Date: 07-Sep-2026
Our Ref: 2026/92108

**TOWN AND COUNTRY PLANNING ACT 1990
TOWN AND COUNTRY PLANNING (GENERAL PERMITTED DEVELOPMENT) (ENGLAND)
ORDER 2015 – SCHEDULE 2, PART 1, CLASS A.1 (g)
AT: 73, West Royd Avenue, Mirfield, WF14 9LB
Prior notification for single storey rear extension**

The proposal is for erection of single storey rear extension. The extension projects 4.5m beyond the rear wall of the original dwellinghouse. The maximum height of the extension is 3.5m, the height of the eaves of the extension is 2.485m

Proposed Floor Plan

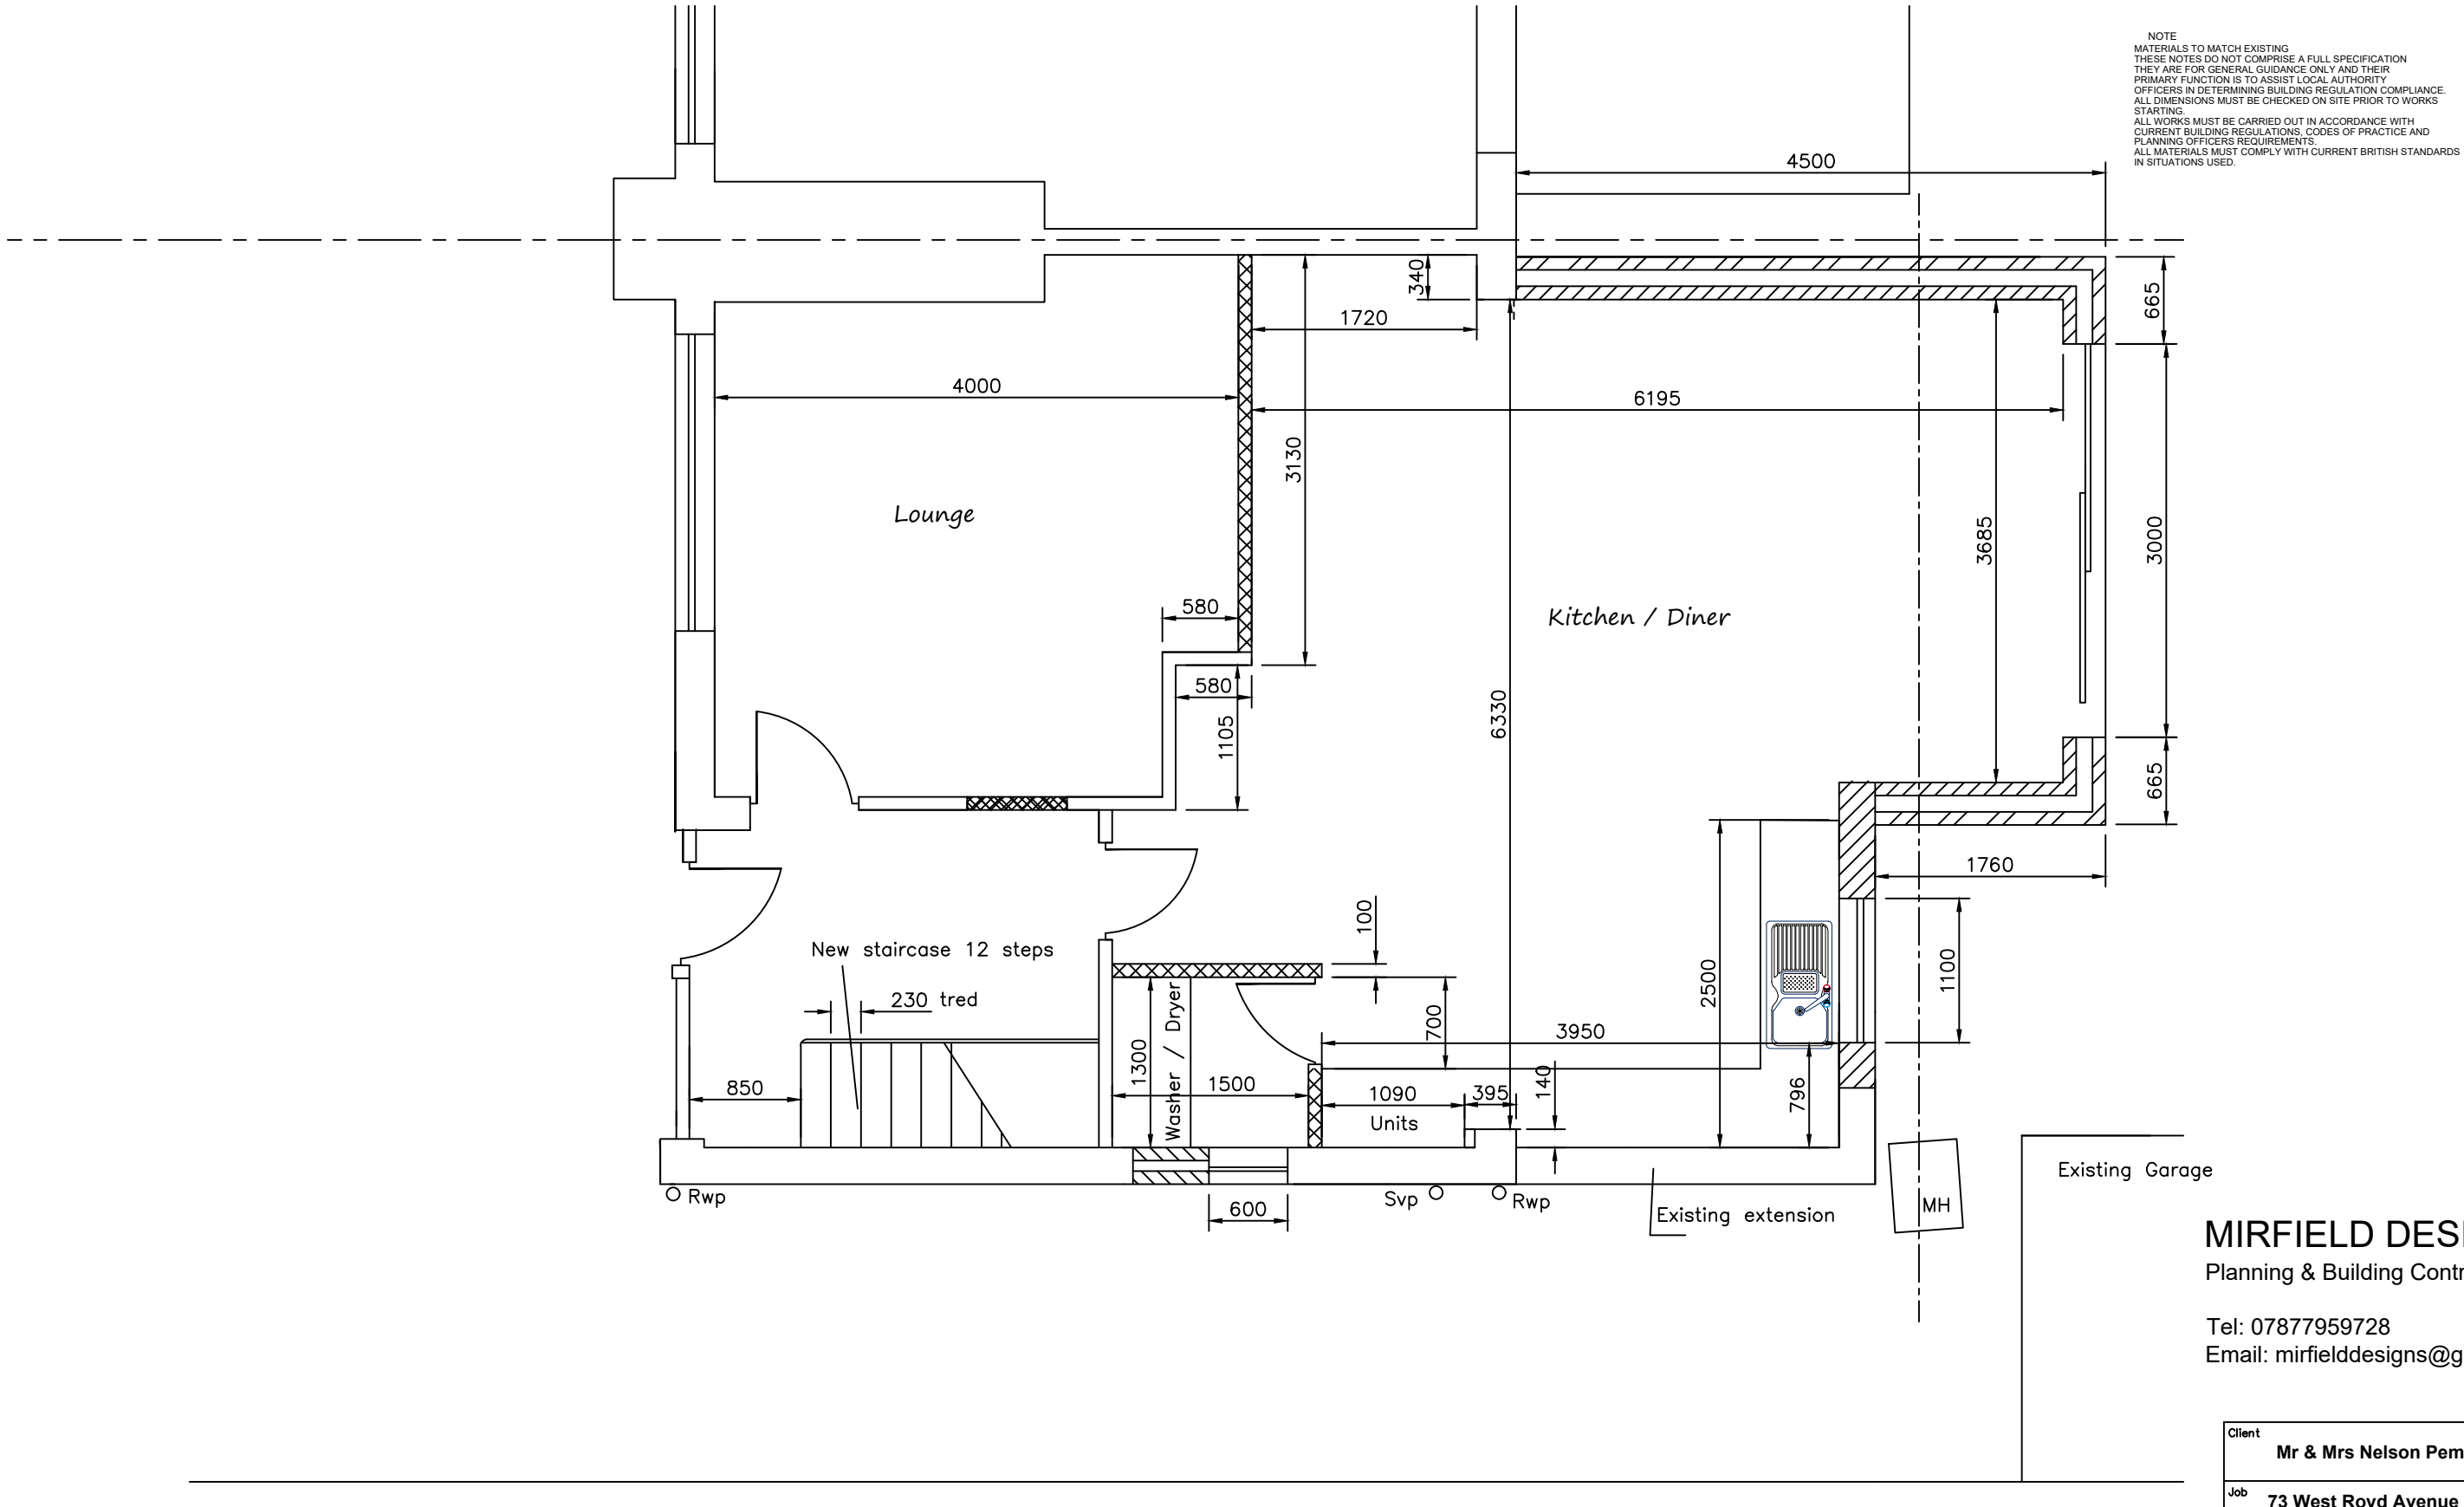
The proposed rear enlargement cannot benefit from a general planning permission under Article 3(1) and Schedule 2, Class A, Part 1 of the Town and Country Planning (General Permitted Development)(England) Order 2015 (as amended) as the proposed enlargement would extend beyond a wall forming a side elevation of the original dwellinghouse and has more than half the width of the original dwellinghouse.
